Our Ref: R/2021/6/A  
File No: 2022/229540  
Your Ref: SSI-22765520

**Advice on EIS  
Sydney Metro West Stage 3 – Rail infrastructure, stations, precincts and operations**

Figure 10. Site plan – Pyrmont Station construction sites

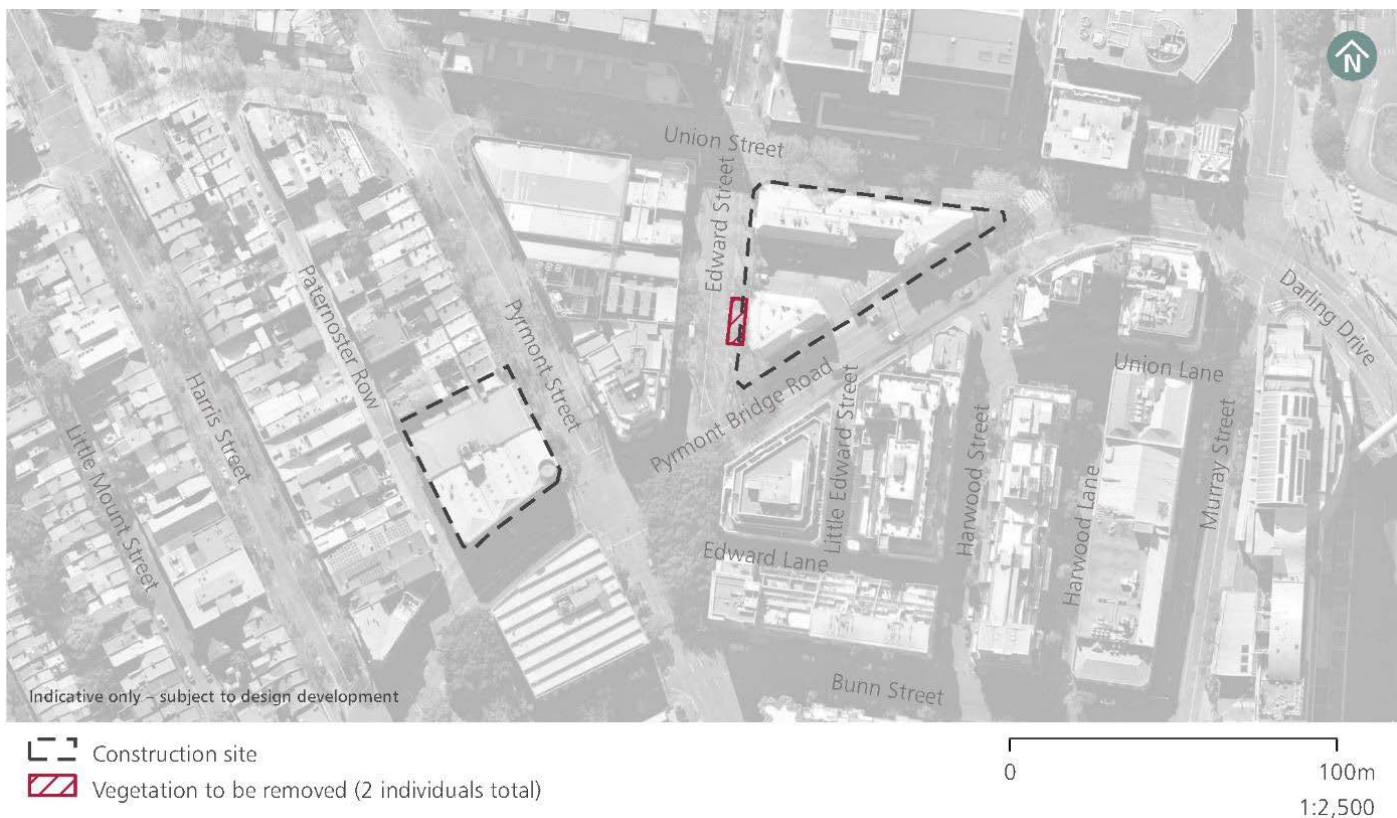
The drawings provided lack clarity and need to better consider the public domain, with more attention to footpath widths reflective of the needs of the volume of pedestrians, spaces for replacement tree planting in the public domain, and appropriate setbacks. The sections provided at Figures 14-2, 14-3 and 14-4 (in Chapter 14 of the EIS) depict the tower envelope extending to the kerb, which would result in an exceptionally poor urban design outcome, inconsistent with the surrounding urban fabric. The public domain and the station envelope's relationship to the public domain appears not to have been adequately considered.

The proposed western entry station building occupies a prominent corner site within the heritage conservation area at the junctions of three streets - Pyrmont Bridge Road, Pyrmont Street and Paternoster Row.

The two existing buildings are to be replaced by a building of four to five storeys (12-15 metres) in height. The proposed station building has the potential to overscale the surrounding built form within the Pymont Heritage Conservation Area and overscale heritage listed buildings within the visual curtilage of the site. The proposed height and scale of the western entry building is excessive in terms of the historic built form of its context.

- Greater consideration of the public domain is required, including clear drawings which communicate proposed footpath widths, street tree planting, and adequate setbacks of the station building envelope
- Further drawings are required to enable to provide meaningful comments.

- The height, scale and bulk of the proposed western entry building should be modified to respond to the predominate low scale of its historic context. The height should not exceed 10 to 12 metres or 3 storeys to provide a transition of scale between the Victorian warehouses opposite the site at 137 Pymont Street and at 17-21 Pymont Bridge Road and the row of two storey Victorian terraces at 115 to 127 Pymont Street and the two storey Quarryman's Hotel at 214-216 Harris Street.
